REPORT UPDATE

Application No: EP/90/09/

PLANNING APPLICATION REPORT**REF NO:** EP/90/09/**LOCATION:** Churchfield
Station Road
East Preston**PROPOSAL:** Demolition of existing buildings & residential redevelopment to provide 14 no. houses & apartments, with associated parking & open space.**SITE AND SURROUNDINGS**

Second Floor Plans

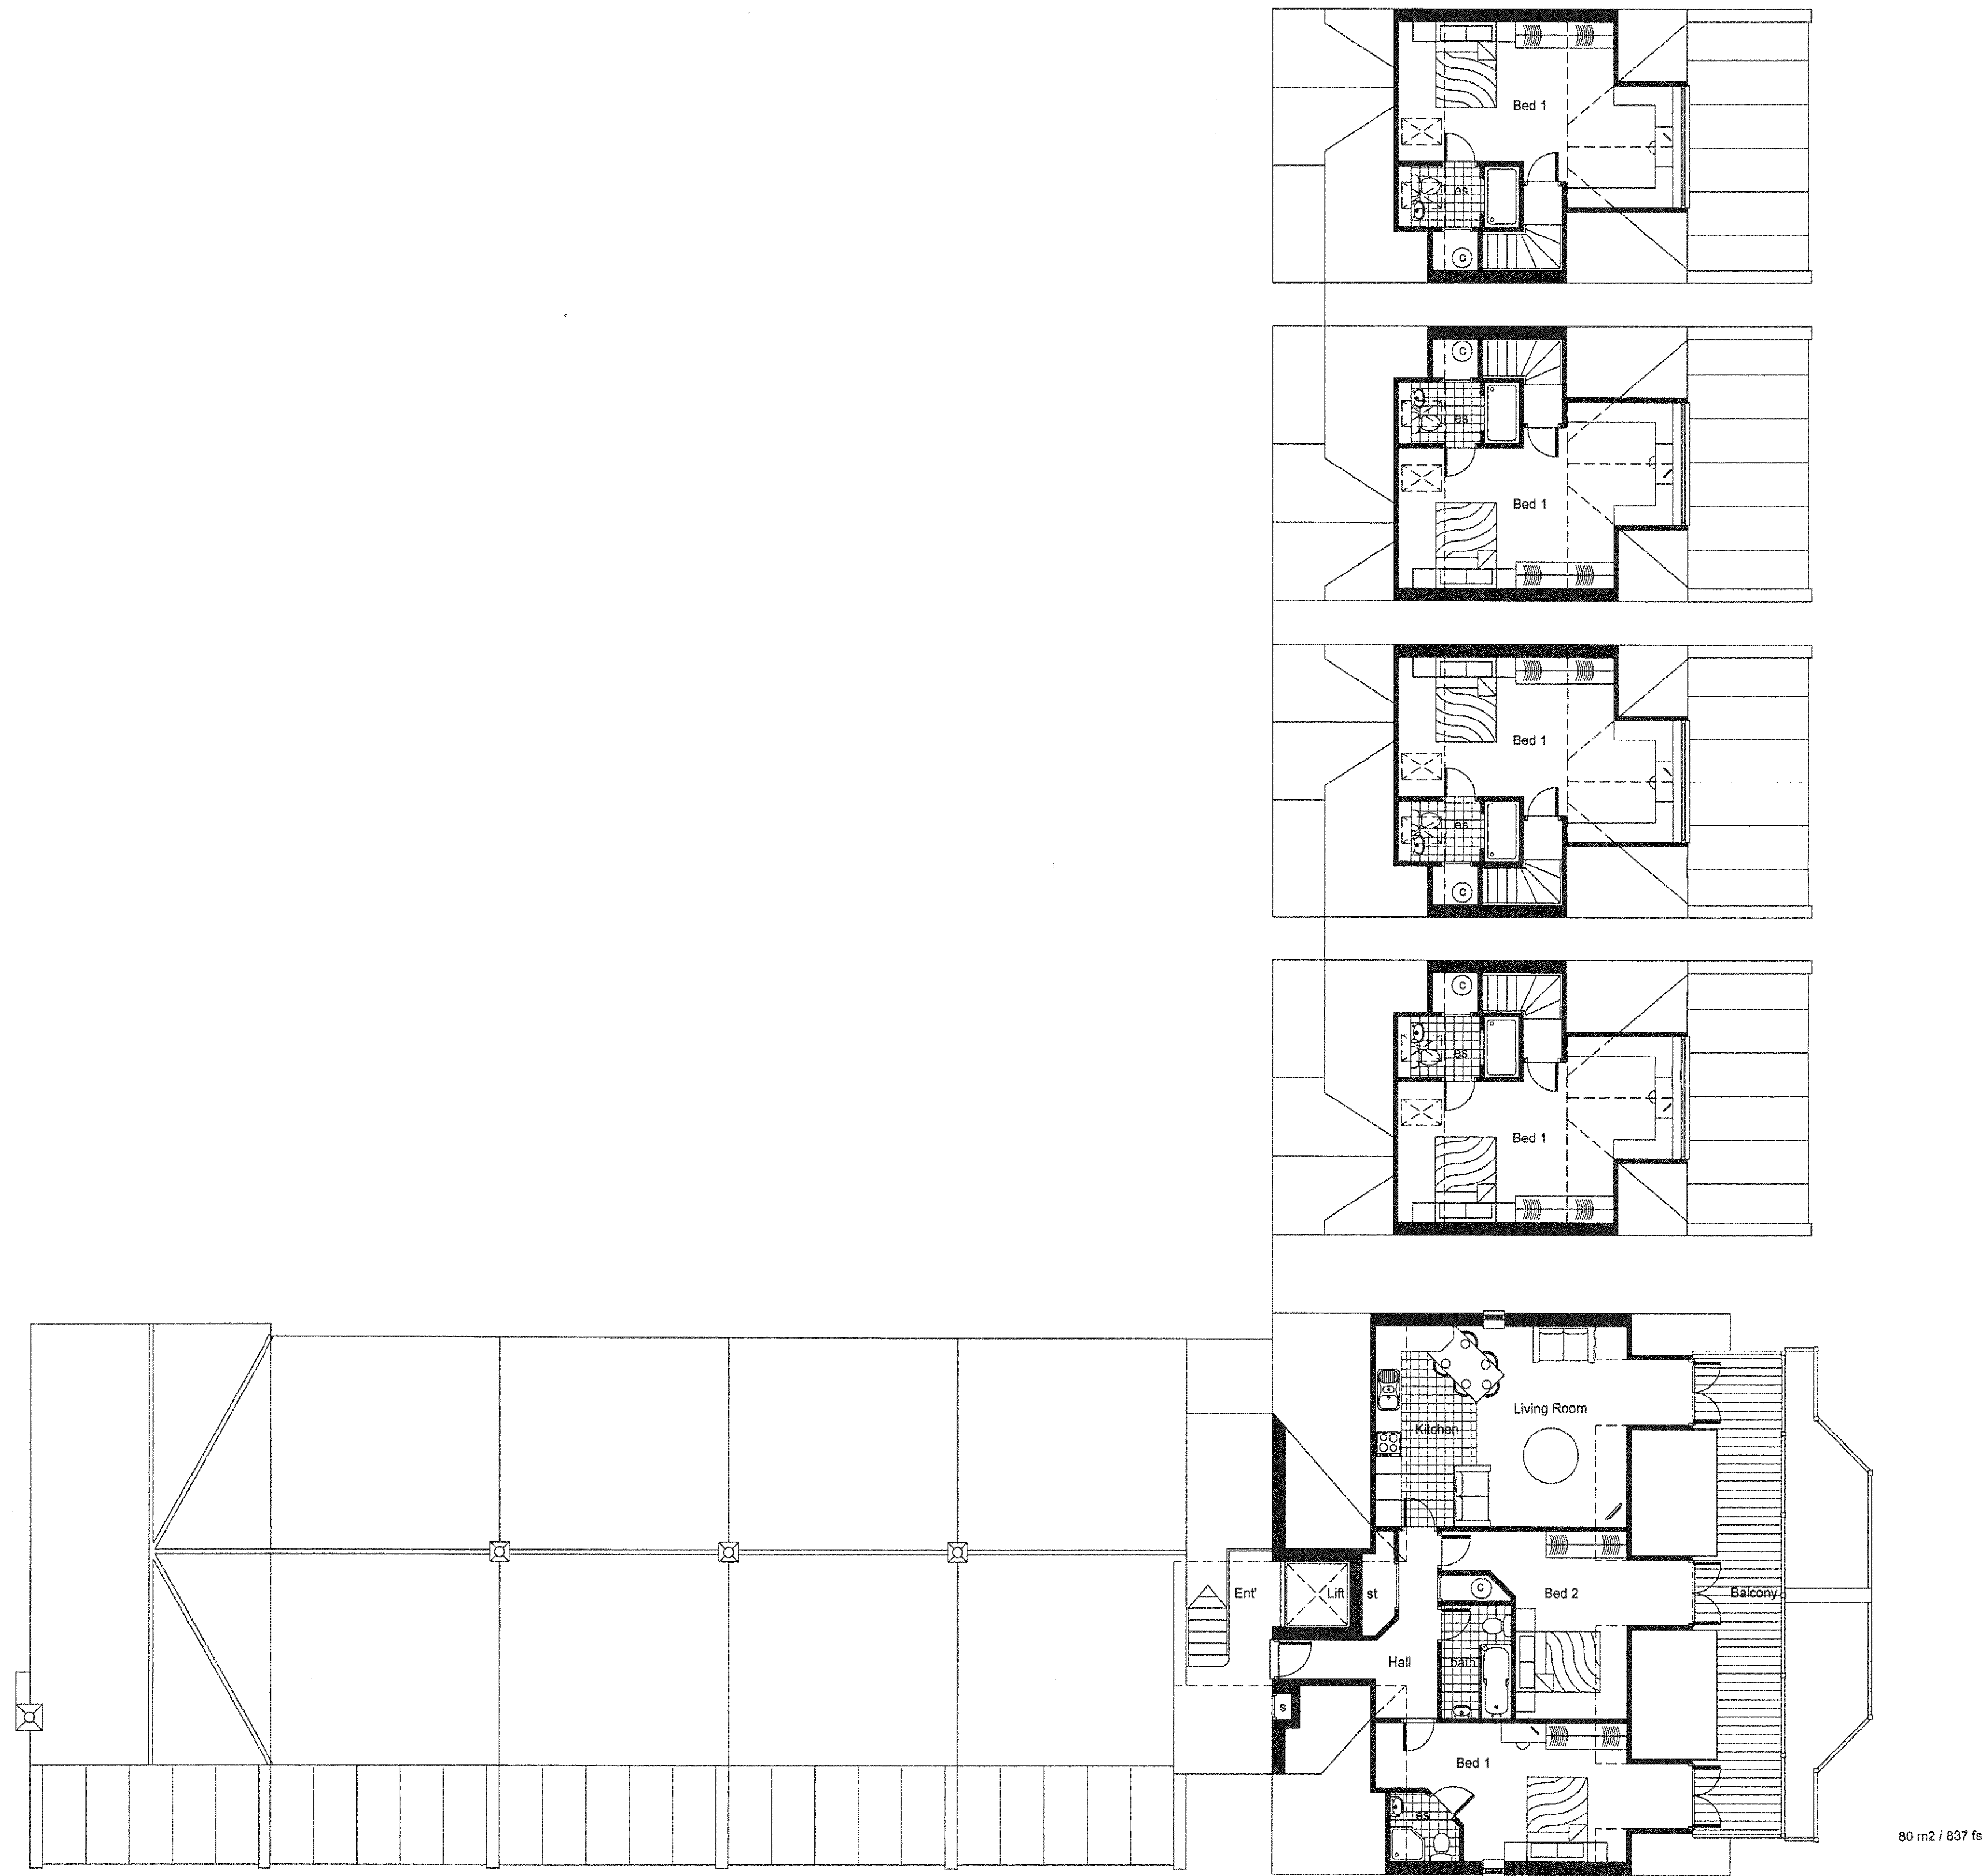
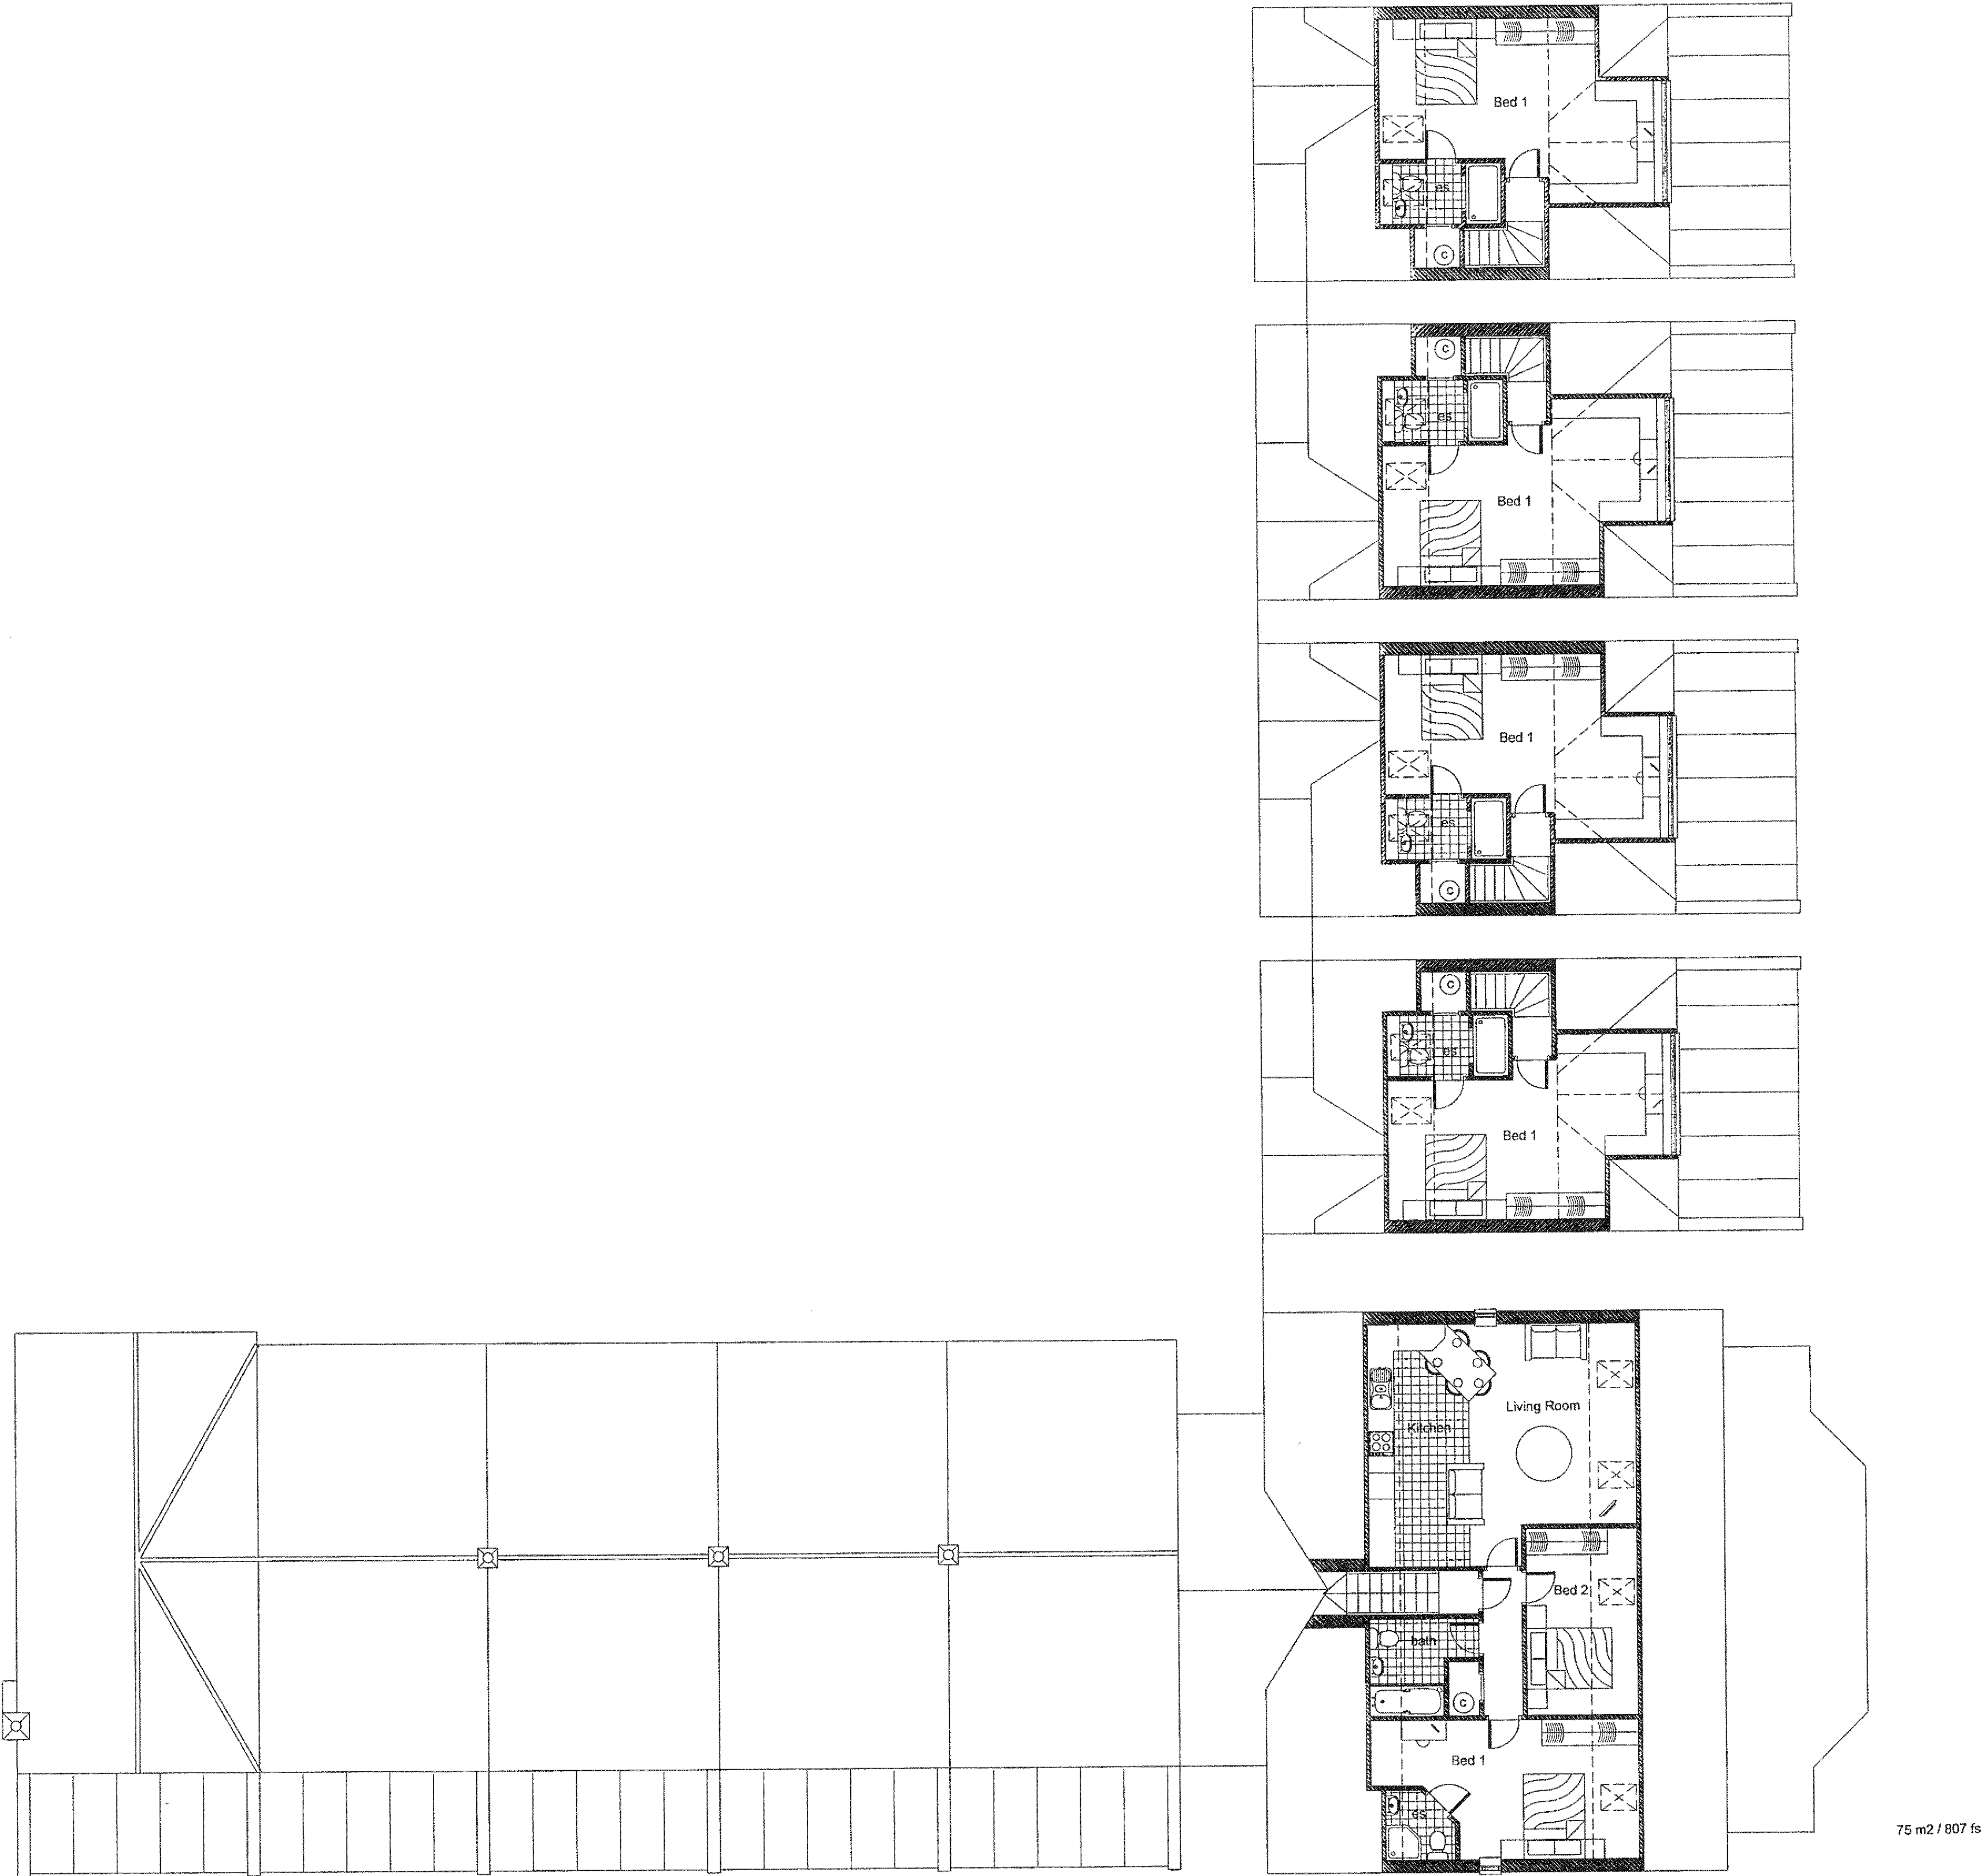
Amended elevational plans have been received which delete the balcony to the 2nd floor of the flats; delete the dormers and doors which were associated with this balcony on the 2nd floor; removed the 2nd floor built link section between the terraced housing and the flats.

The amended elevations are acceptable design changes brought about following discussions with the LPA.
